**Our ref:** HA/2018/120664/01-L01  
**Your ref:** LU/182/18/PL  
**Date:** 29 August 2018

**DEMOLITION OF THE EXISTING BUILDINGS & ERECTION OF 2 NO. NEW BUILDINGS INCORPORATING COMMERCIAL (A1) AT GROUND FLOOR WITH 4 NO. RESIDENTIAL UNITS ABOVE.**

**46A & 46B PIER ROAD, LITTLEHAMPTON, BN17 5LW.**

drawing Proposed Section AA

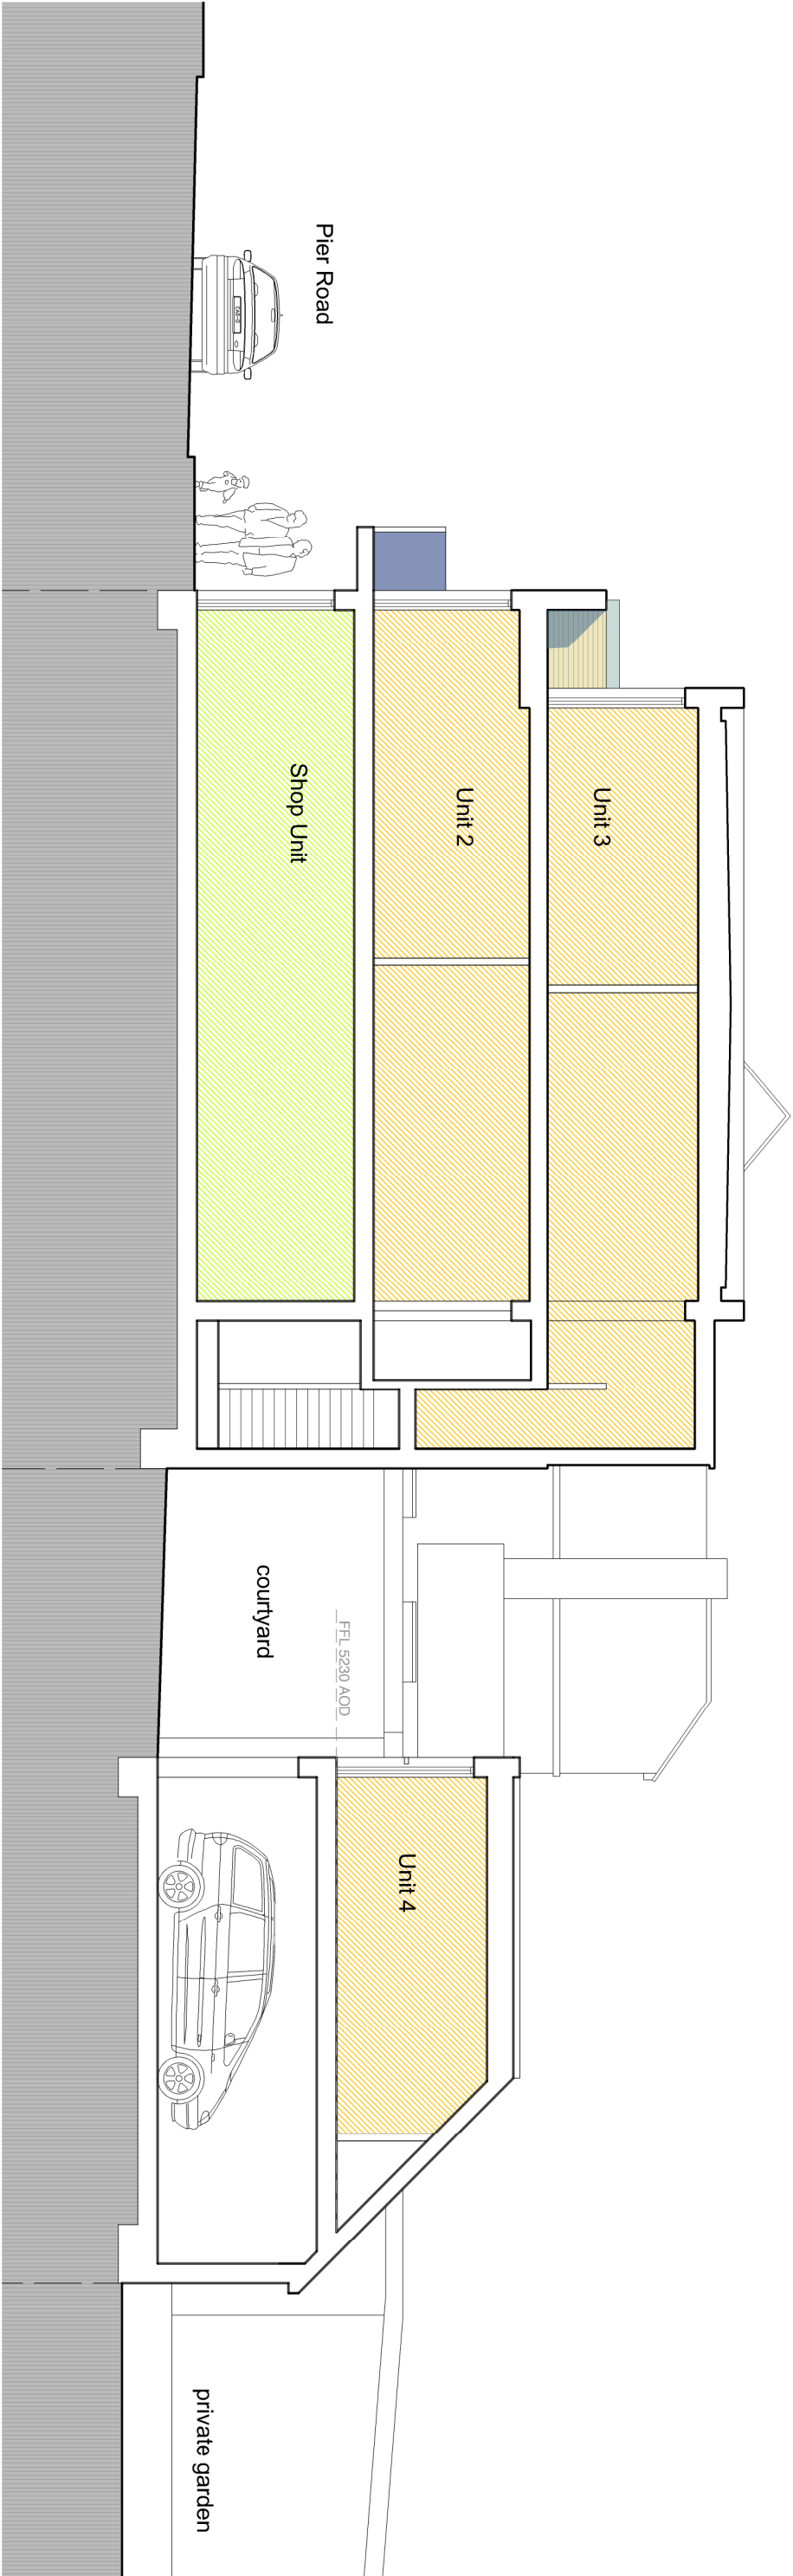
- Finished floor levels for habitable room are set no lower than 5.23 metres above Ordnance Datum (AOD).
